## Memorandum

SUBJECT: Down Short Plat (SP-12-00007)

# 4' Contour Map

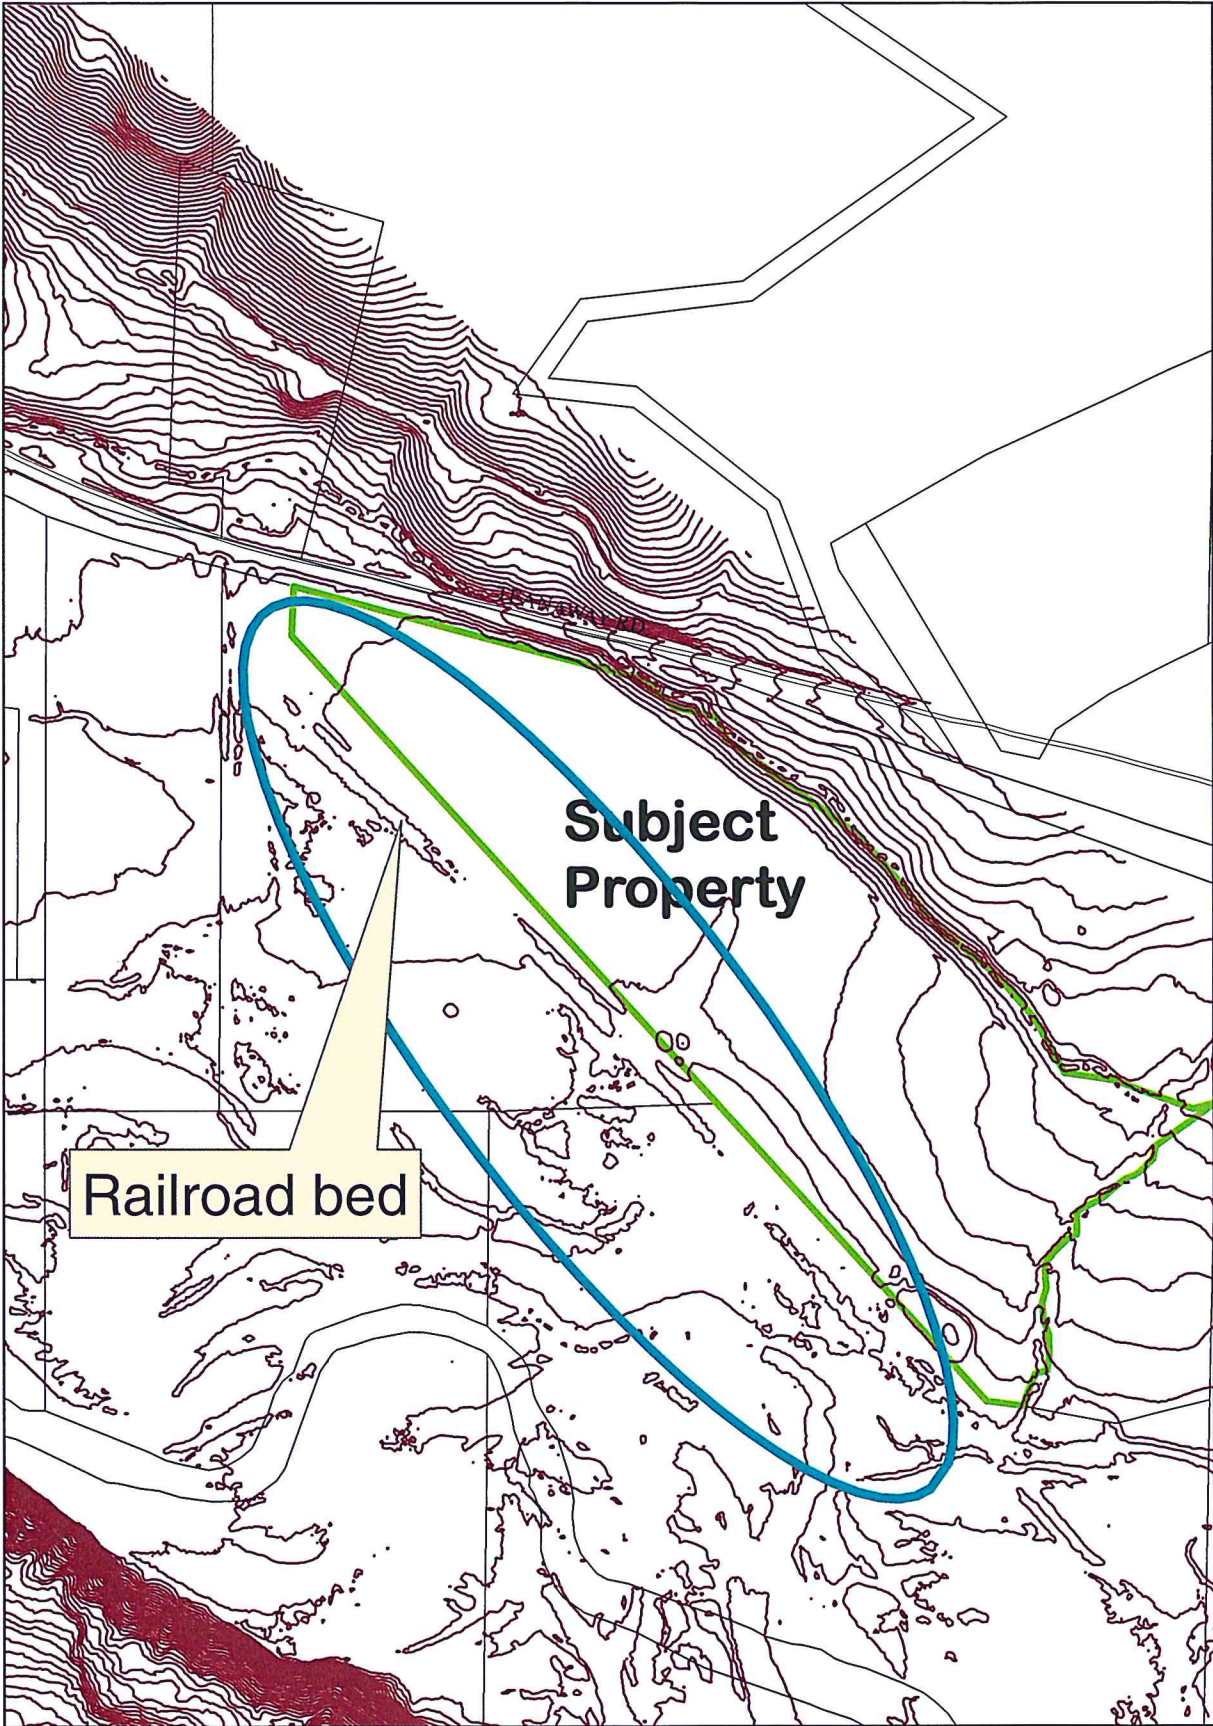
1. There is not a shoreline designation associated with the Teanaway River on the subject property associated with the Teanaway River. The subject property is at least 200 feet from the ordinary high water mark of the Teanaway River. Please see the attached map depicting a 200 foot buffer between the OHWM and the subject property.
2. The "road/dike" mentioned in the email from Mr. Teske appears to be located south of the subject property; which is out of the purview of the property owners. Staff believes it is actually the old railway bed for the logging operations that existed in the Teanaway Valley in the early 1900s. Please see the attached contour map and the aerial located within the project file.
3. Mason Creek is regulated by Kittitas County Code 17A. At the time of building permit submittal, appropriate measures in conformance with KCC 17A will be enforced.
